**WEST SUSSEX COUNTY COUNCIL
INFRASTRUCTURE CONSULTATION**

SUBJECT: A/24/10 - Outline application for erection of new warehouse

Land North East of Robert House Rudford Industrial Estate Ford

R.T.Page & Sons Ltd
Land at Rudford Industrial Estate, Ford Road, Ford, West Sussex, BN18 0BD:
PROPOSED NEW WAREHOUSE - VEHICLE PARKING and ACCESS - 1/500 scale

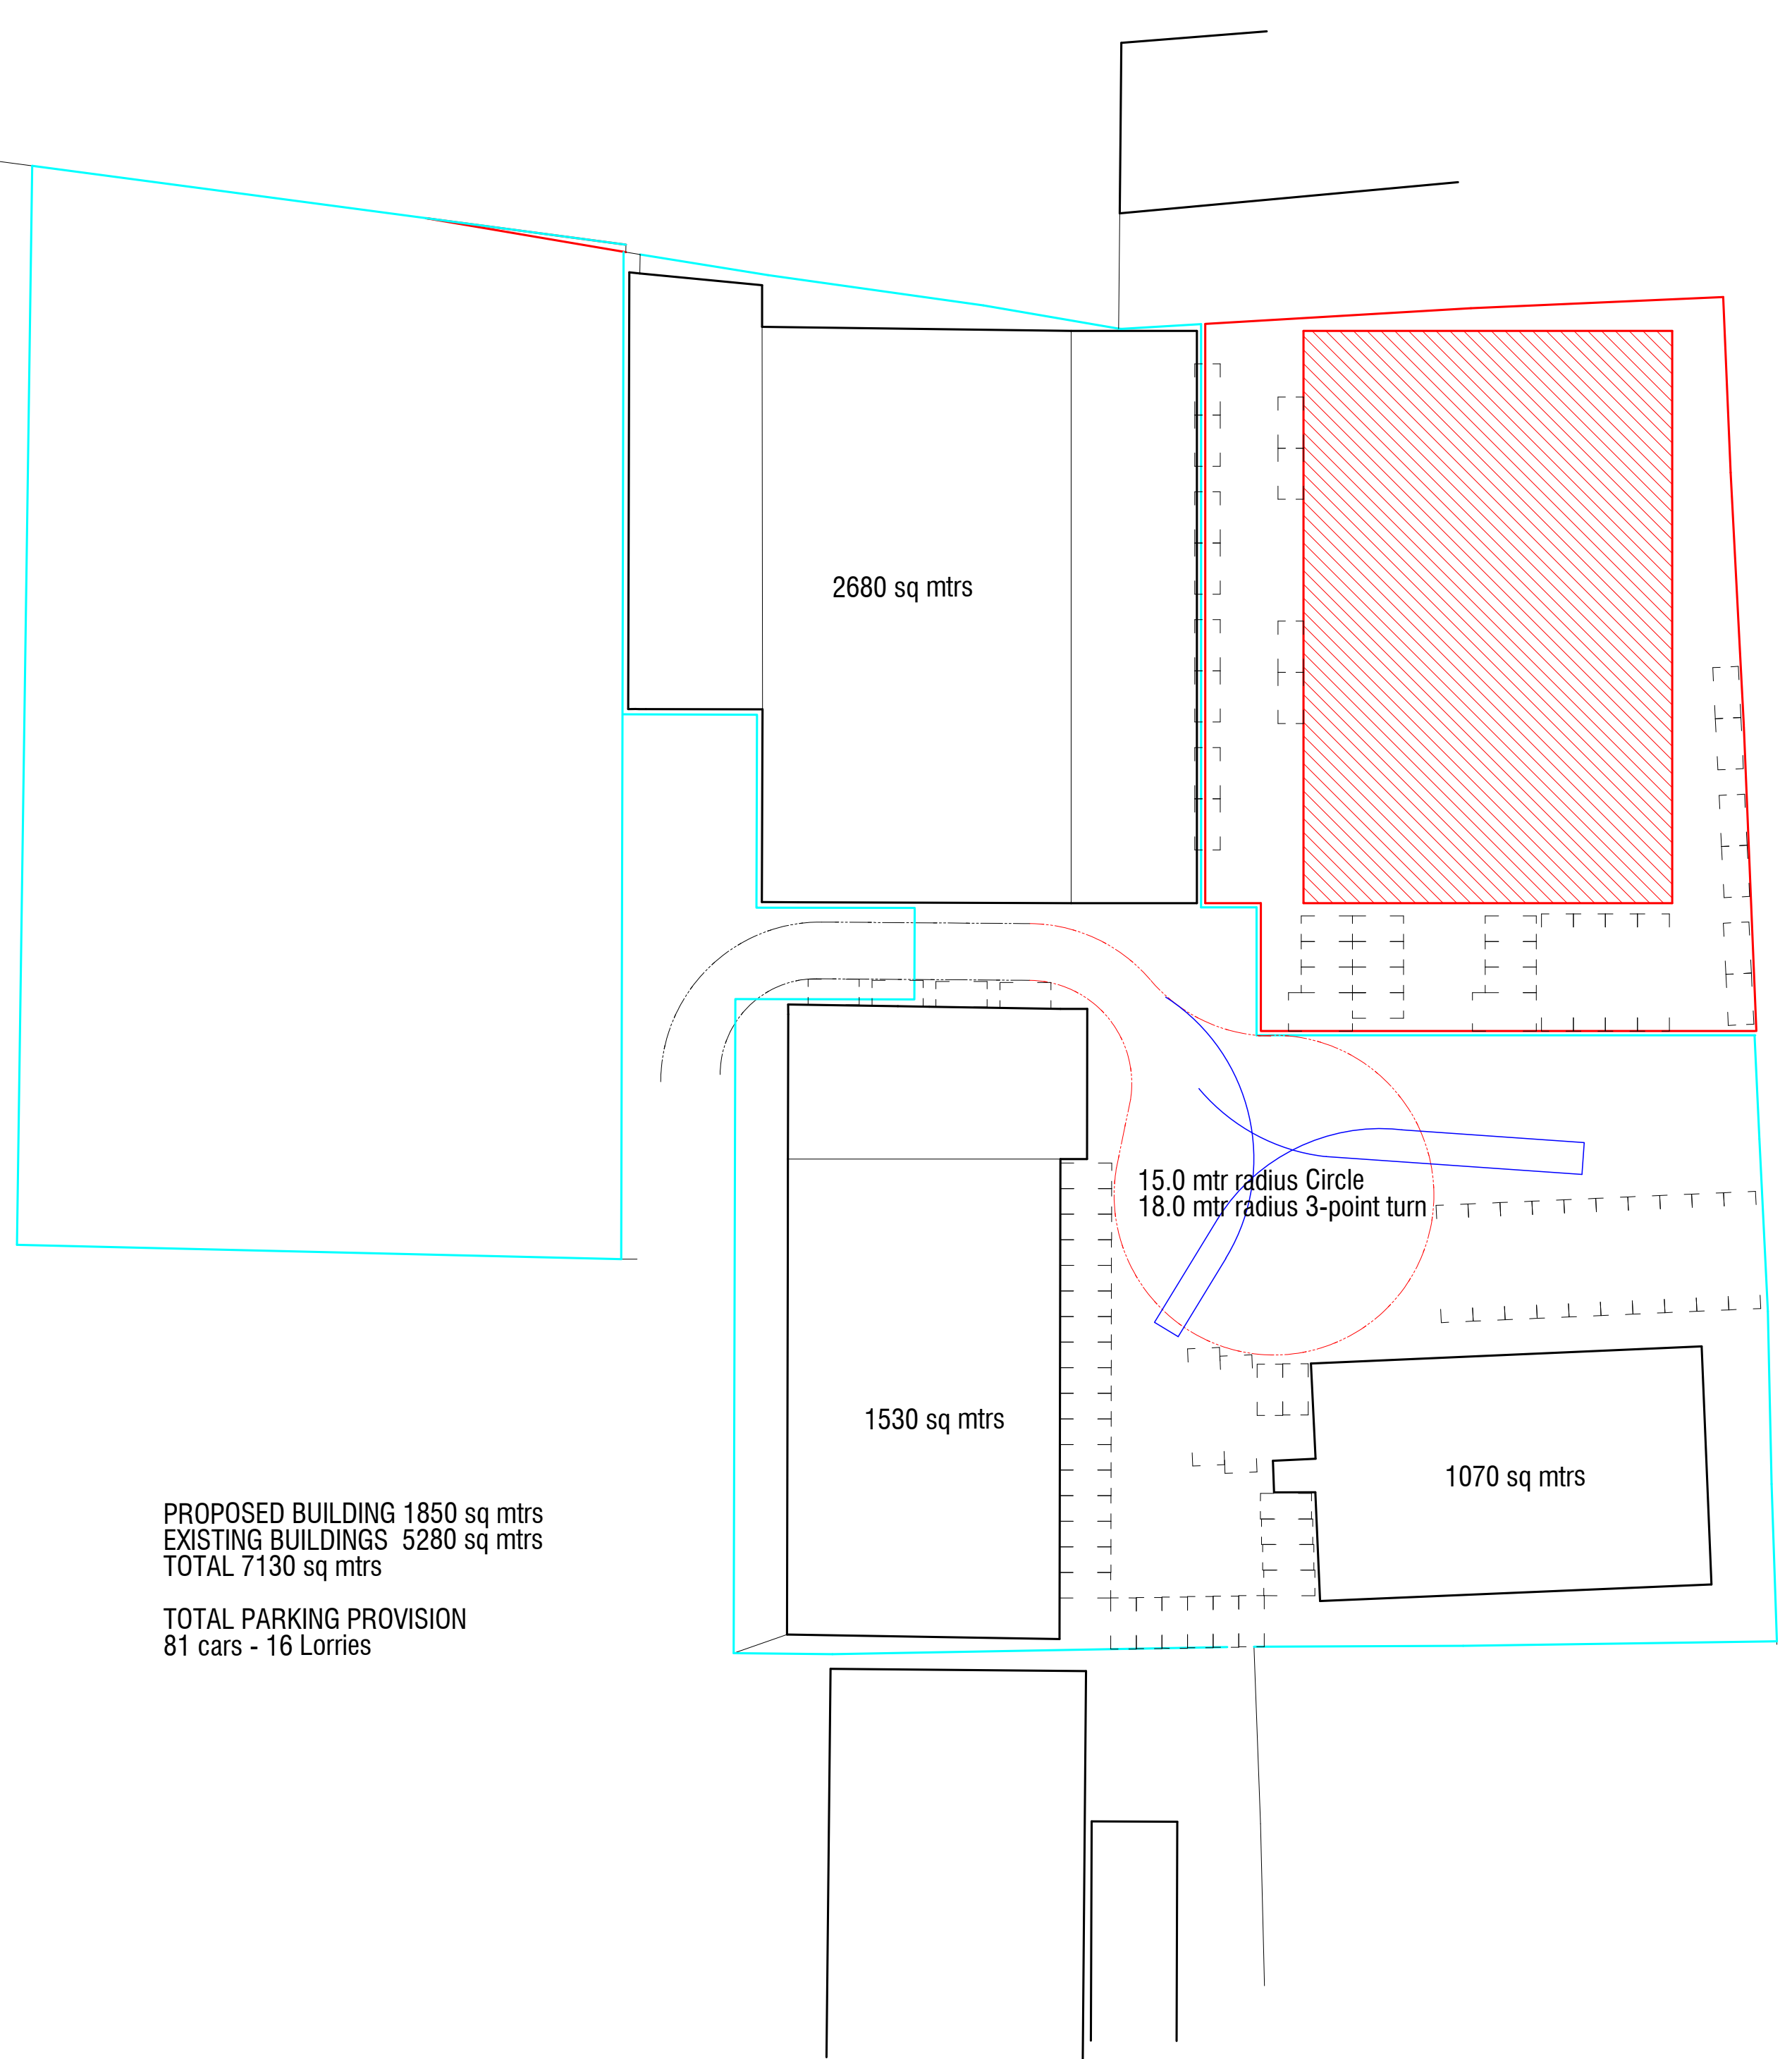
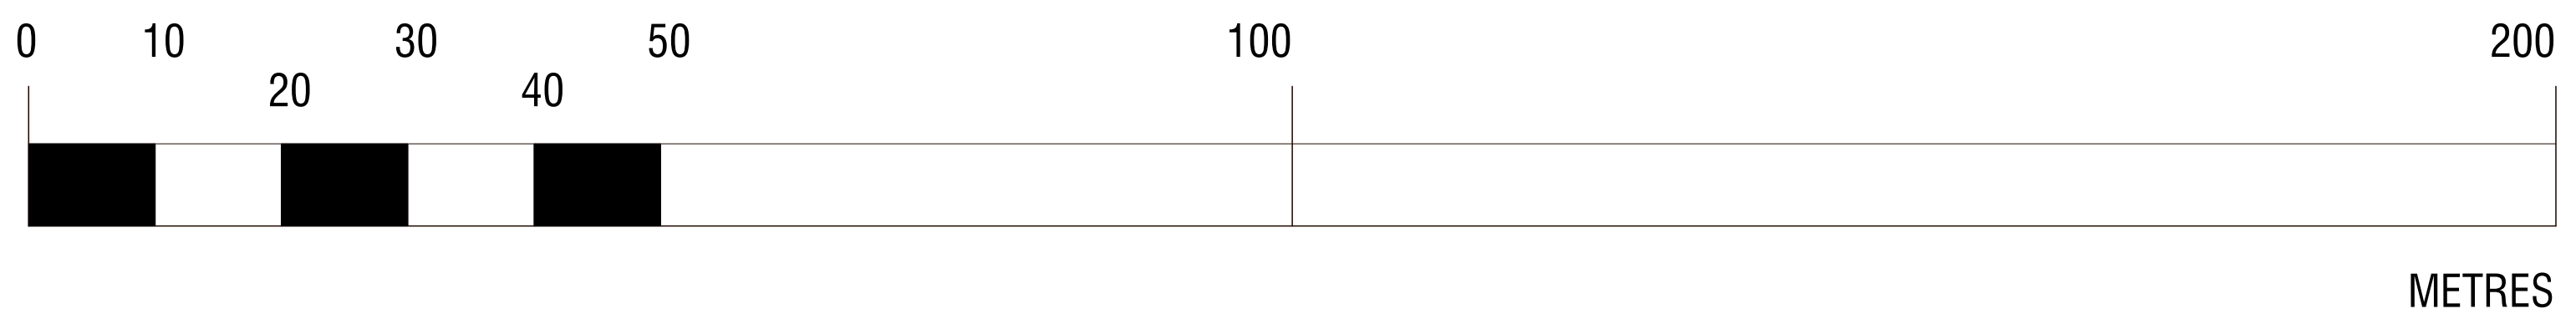
1. Evidence of the likely daily usage of the site by LGVs and other vehicles
2. Details of proposed conjectural parking and turning arrangements for all vehicles.

These details suggest that the site would be able to function safely under its proposed usage and that the likely impact on the local highway network can be accommodated. There is therefore no objection to the application.

No new development shall be occupied until space has been laid out within the site in accordance with a scheme to be submitted to and approved in writing by the Local Planning Authority for maximum (18) cars/minimum (6) cycles to be parked and for the loading and unloading of 2 vehicles and for vehicles to turn so that they may enter and leave the site in forward gear. The parking/turning area shall be used and retained exclusively for its designated purpose.
